STATE OF NORTH CAROLINA
DEPARTMENT OF TRANSPORTATION

SUBJECT: Project 35993.1.1 (U-4700) Caldwell, Catawba, and Burke Counties
F. A. Project NHF-321(18)
Proposed US 321 Widening from US 70 in Hickory to Southwest Boulevard in Lenoir

**Post-Public Meeting
Meeting Summary**

GRACE CHAPEL RD. ALTERNATE DESIGN 1 - SUPER STREET

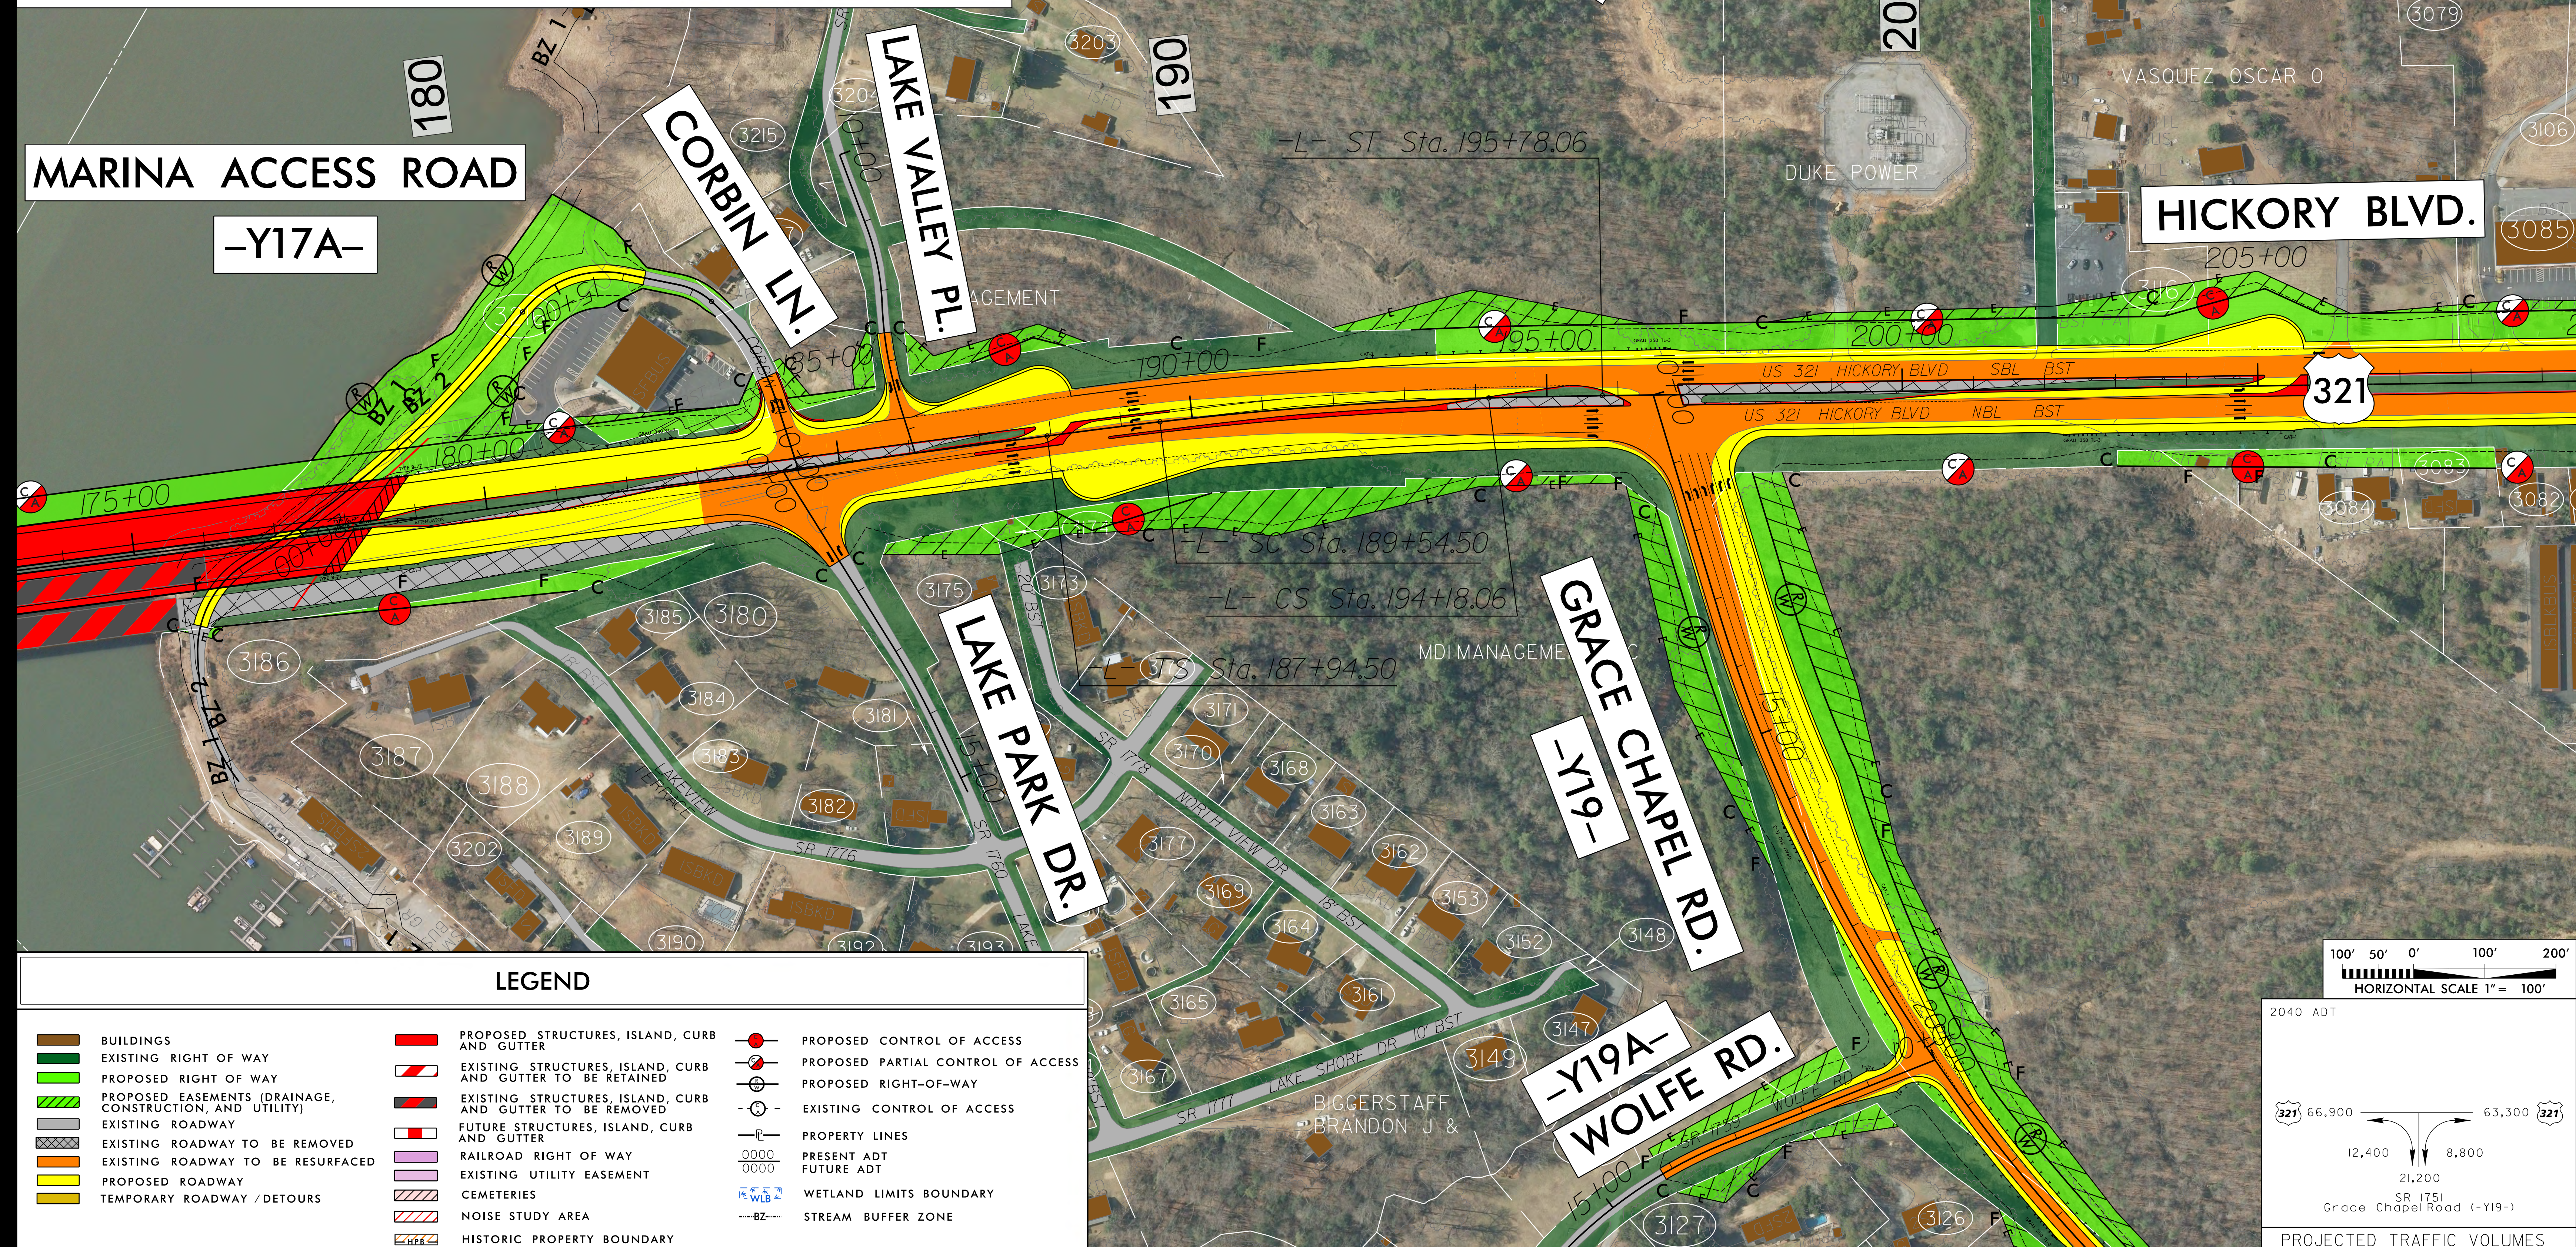
3. **Comment:** It will be difficult to access US 321 from Grace Chapel Road, Lakeview Park, and River Bend/New Farm Road.

Response: Although the route is slightly different, travel time would be on average shorter for the new alternatives compared with the existing roadway configuration. The reverse superstreet and interchange alternatives initially presented in July 2016 would address left turn demand more directly. The recommended alternative proposes a flyover at Grace Chapel Road. New Farm Road connects with Grace Chapel Road.

GRACE CHAPEL RD. ALTERNATE DESIGN 2 - 40MPH FLYOVER

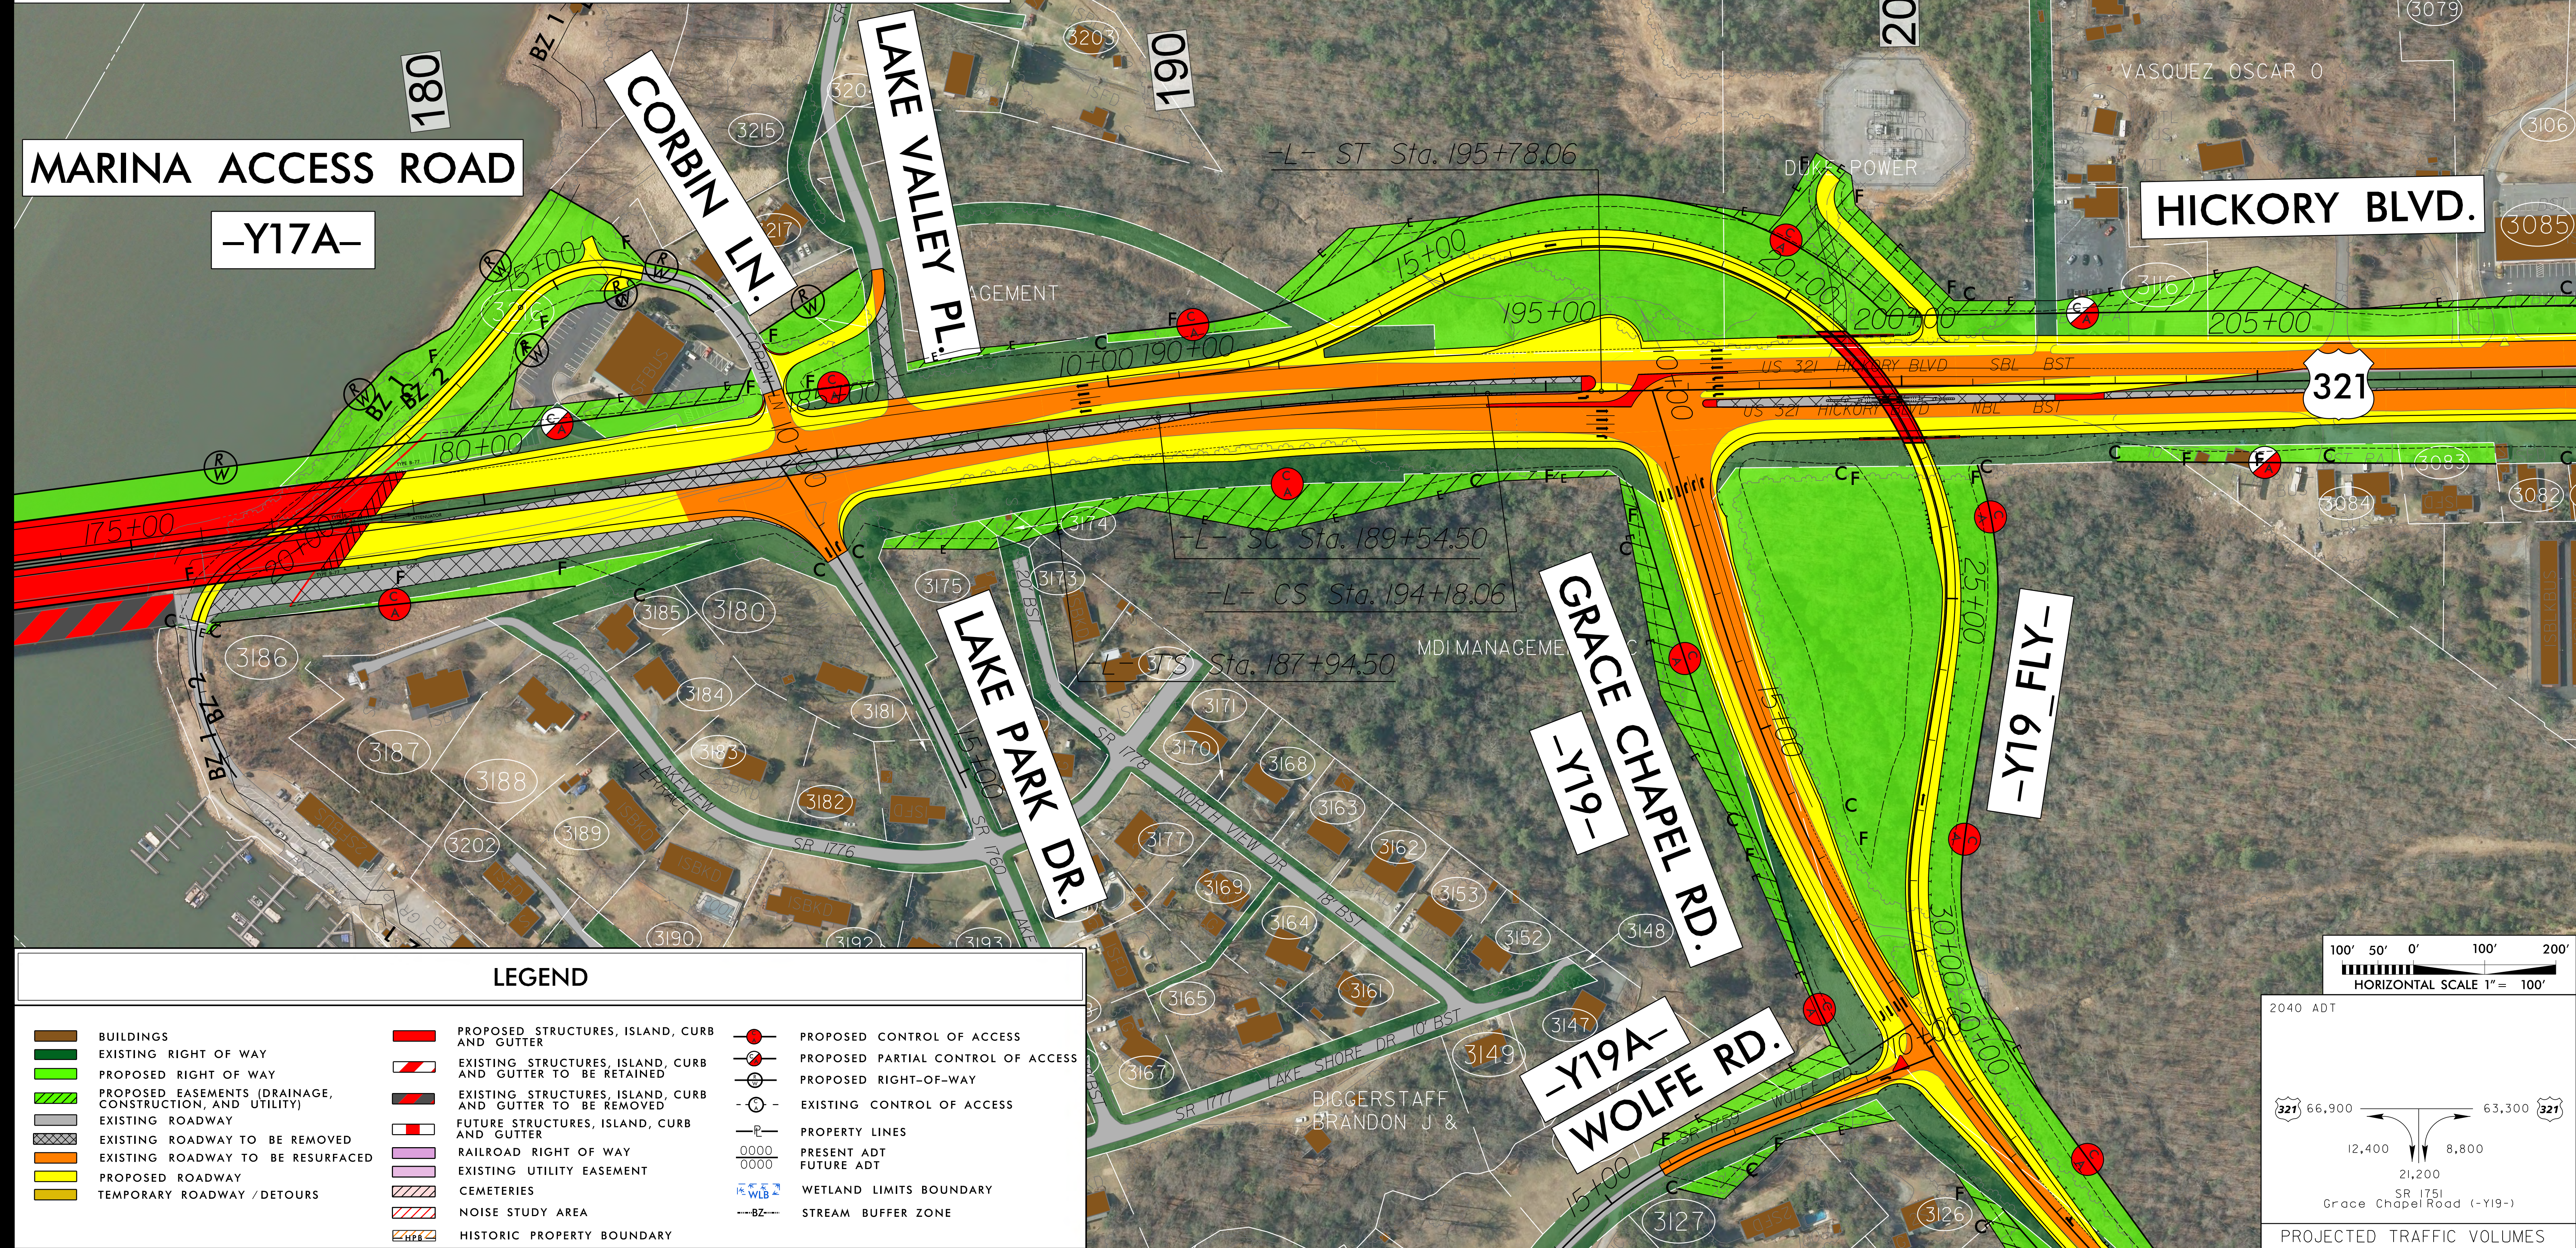
1. **Comment:** The new design benefits MDI and not residents.

2. **Comment:** A large proportion of this area’s arterial street traffic routinely turns left.

6. **Comment:** The proposed design is ignoring a large population that lives near Grace Chapel Road and uses it to access 321.

8. **Comment:** Keep the 2016 plans.

9. **Comment:** Leave the signal at Grace Chapel Road.

Response: Based on the updated forecast, none of these three intersections (Grace Chapel Road, MDI/Alex Lee Boulevard, Walmart/New Farm Road) require an interchange to address traffic operations or congestion concerns. At the July 2017 meeting, the interchange was proposed at a central location (Alex Lee Boulevard) to provide direct access for all users in this area. The recommended alternative proposes a flyover from Grace Chapel Road to US 321 South, and an interchange on US 321 at Alex Lee Boulevard/MDI.

Response: While a superstreet option provides a safe and efficient operation for motorists, the reverse superstreet and interchange alternatives initially presented in July 2016 would provide direct movements for the heaviest turn movement Grace Chapel Road, and the interchange presented in July 2017 would provide direct movements for the heaviest turn movements via Alex Lee Boulevard. Since Grace

Chapel Road and Alex Lee Boulevard intersect east of US 321, traffic from this area could use either route. The recommended alternative proposes a flyover at Grace Chapel Road and an interchange at Alex Lee Boulevard, providing a direct movement for left-turning vehicles from both roads onto US 321 Southbound.

Response: There were three options at Grace Chapel Road presented at the 2016 public hearing, based on the 2011 traffic forecast. This forecast assumed all traffic would be concentrated on Grace Chapel Road because New Farm Road was not in place at that time. Based on an updated traffic forecast (2017), a fourth option (a traditional superstreet) was added for consideration, and presented during the July 2017 public meeting. The recommended alternative proposes a flyover at Grace Chapel Road.

Response: With a traditional traffic signal, the intersection Grace Chapel Road at US 321 is projected to operate with long delays. Also, leaving the existing traffic signal at this location would interrupt the signal timing progression along US 321, affecting travel time and delay for all drivers on the corridor. With addition of a superstreet or a reverse superstreet, a signal would still be included to ensure drivers had sufficient gaps to get onto US 321. With the preferred alternative, a southbound flyover to US 321, a signal is proposed to remain at the at-grade intersection of Grace Chapel Road and US 321 to ensure drivers have sufficient gaps to turn right from Grace Chapel Road onto US 321, and to turn left from US 321 onto Grace Chapel Road.
